WEST SUSSEX COUNTY COUNCIL CONSULTATION

TO:	Arun District Council FAO: Ross Leal
FROM:	Highways, WSCC
DATE:	02/05/2018
LOCATION:	Land adjacent to, 30 Ellis Close, Arundel, BN18 9LG
SUBJECT:	AB/39/18/PL Erection of 3 No. 2 bedroom dwellings with associated parking & landscape.
DATE OF SITE VISIT:	n/a
RECOMMENDATION:	Advice
S106 CONTRIBUTION TOTAL:	n/a

Site Plan 1:200

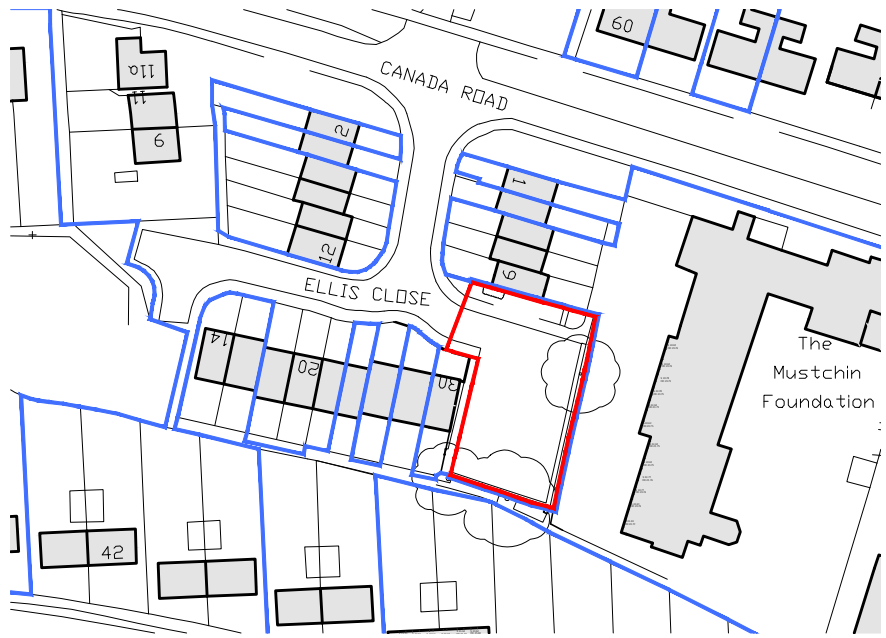
The internal site layout of the site will require the use of an 'E' class footway known as 'Ellis Close to Car Park'. For the scheme to be implemented this area of land would need to be 'Stopped Up' i.e. have the highway rights extinguished.

In planning terms the loss of this highway is mitigated by the shared surface access and turning area which can be used to facilitate access to the rear of 1- 9 Ellis Close (odds only).

In order for the permission to be implemented the Public Highway in question must first be 'Stopped Up' and have its highway rights extinguished. Providing the development has not commenced this process can be sought under S 247 of the Town and Country Planning Act 1990, and is administered by the Department of Transport National Transport Casework Team. Prior to commencement the applicant would be advised to complete the 'Stopping Up' Process. The granting of planning permission and comment provided here does not guarantee that a 'Stopping Up' application, which will be subject to additional consultation, will be successful.

The proposed dwellings will be afforded 6 hardstanding parking spaces, allocated on the basis on 1 space per dwelling, with the three remaining spaces left unallocated for visitors and general use to mitigate for the loss of the general parking area.

Each dwelling should be provided a secure and covered cycle parking provision; I note this has been indicated on the proposed site plan.

The parking layout is adequate to provide vehicles the opportunity to turn on site.

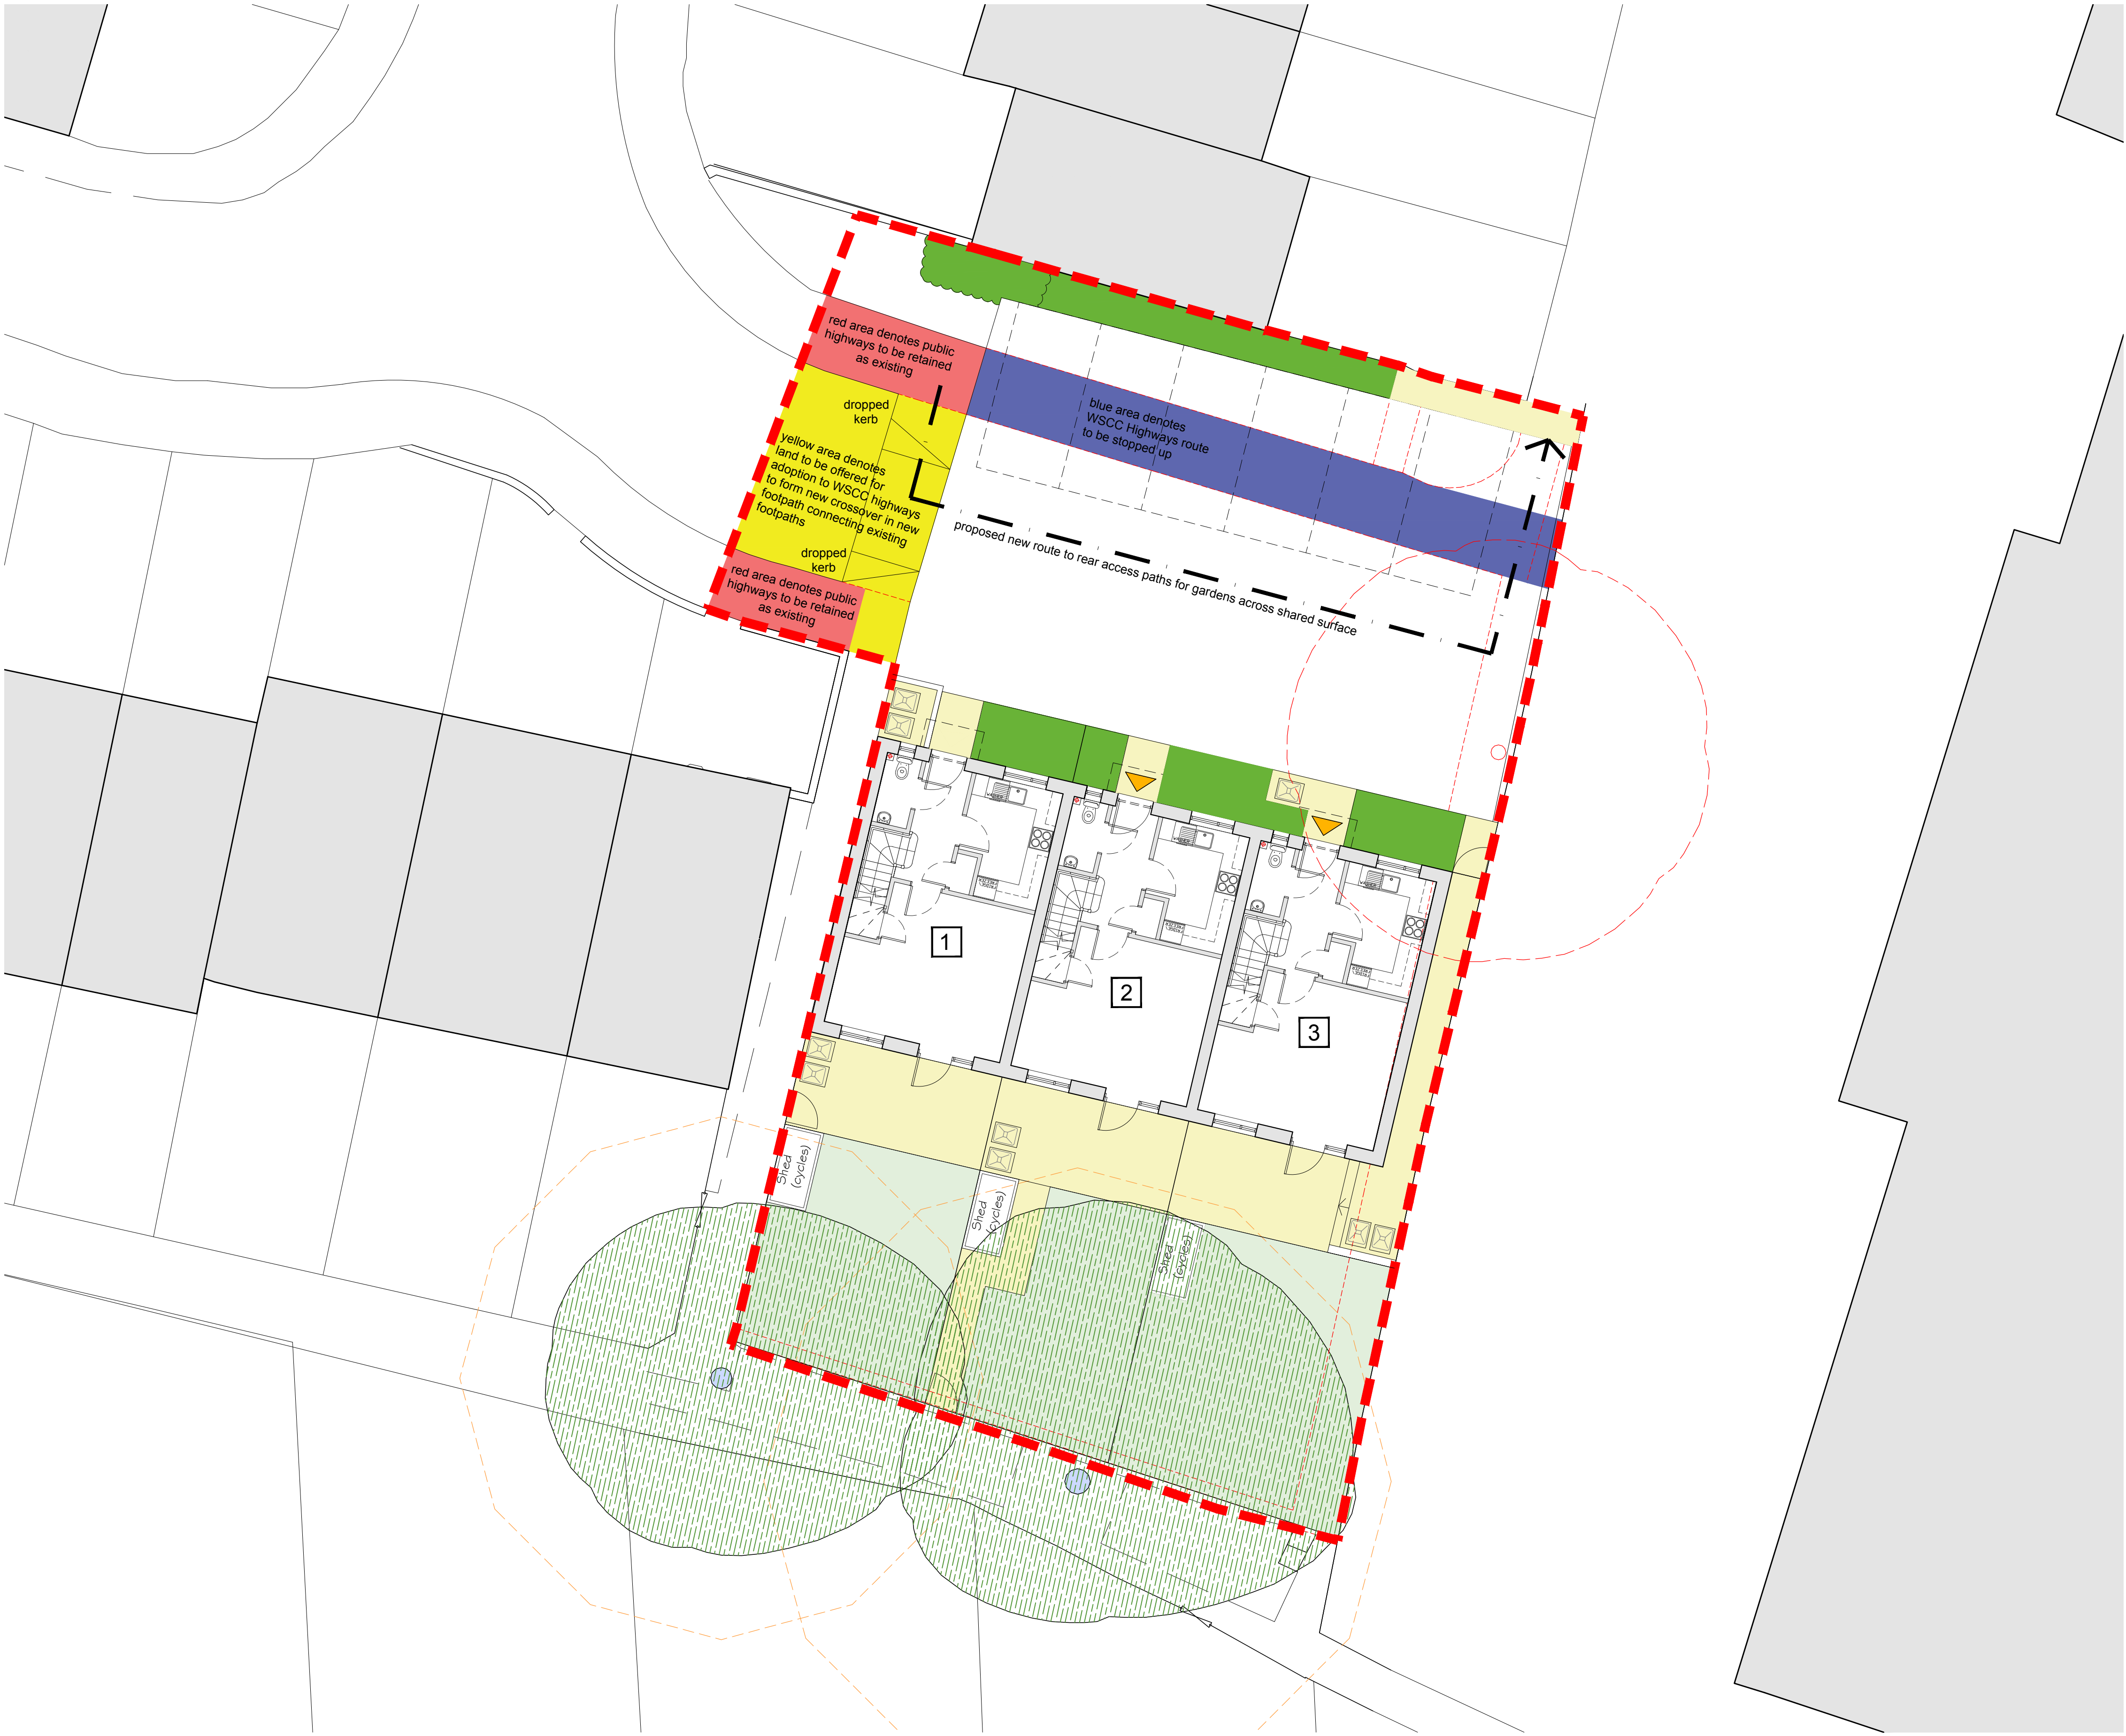
A site plan has been provided showing Highway Information (16/021 012 P2). This details an area of the access point which will be offered for adoption.

Any adoption of public highway would need to be formally agreed via a Section 38 Agreement. The Local Highways Authority does not typically seek to adopt areas of public highway such as this unless there is a significant benefit to the public.

Upon review of the site access it does not seem there is any requirement or benefit to the public by adopting this part of the access arrangements.
